Our ref: DOC23/79173
Your Ref: SSD-7942-Mod 2

Subject: SSD 7942 Mod 2 Open Water Surf Facility – Sydney Olympic Park

Thank you for your email received 31 January 2023 requesting comments from the Environment and Heritage Group (EHG) on Modification 2 (SSD-7942-Mod 2) for the Open Water Surf Facility located at Pod B, P5 car park, Hill Road, Sydney Olympic Park.

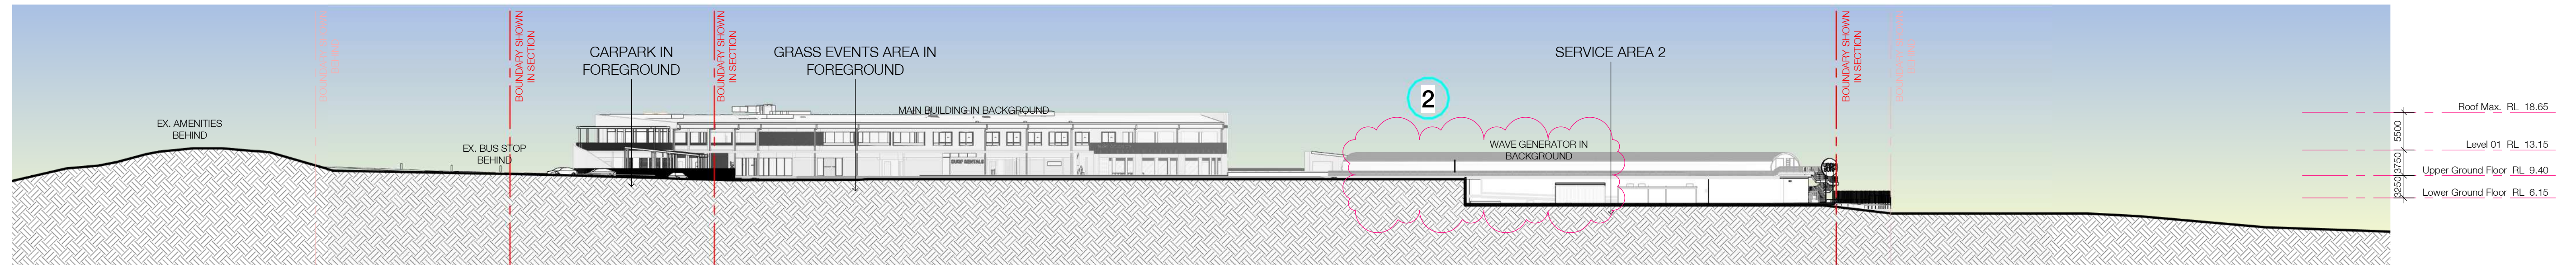
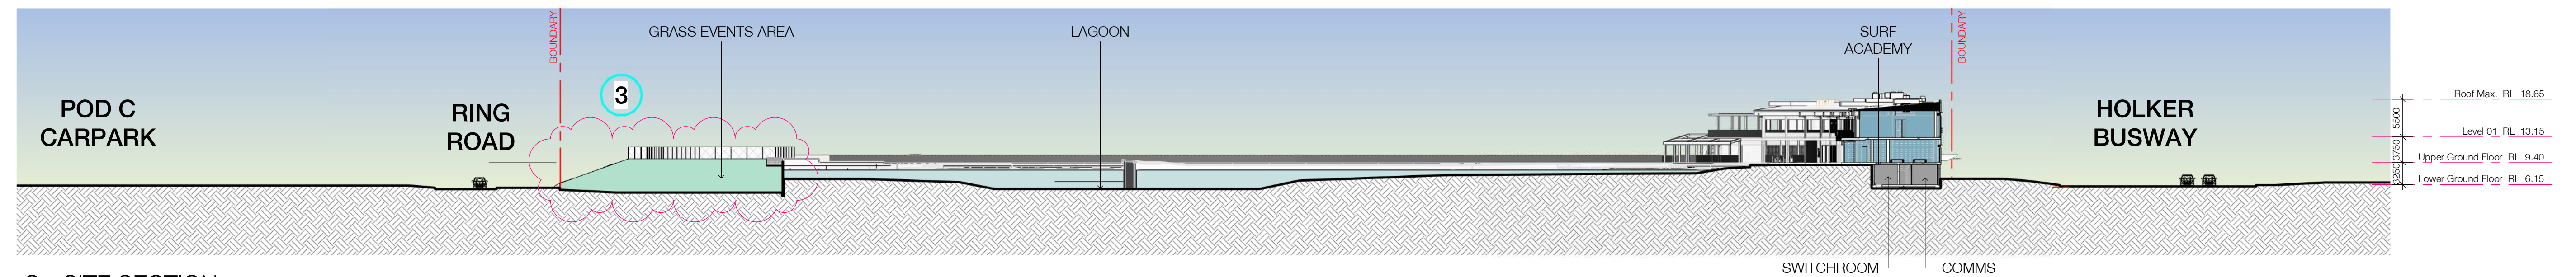
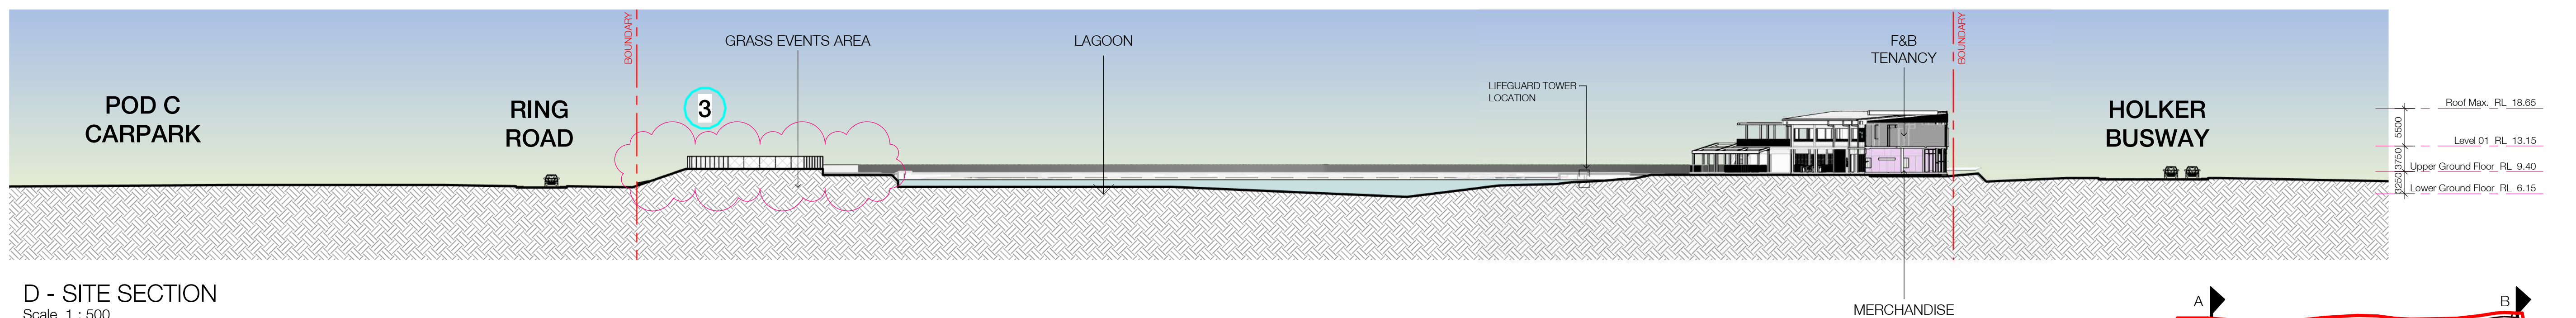
EHG recommends that the application address section 7.17 of the Biodiversity Conservation Act, 2016 (BC Act), noting that impacts include both direct and indirect impacts. The site is surrounded by highly sensitive environments zoned C2 and EHG is particularly concerned about potential impacts from alterations to the levels and subsequent potential erosion and sedimentation impacts,

as well as any changes to landscaping that may potentially allow for greater noise and light spill into adjacent sensitive areas.
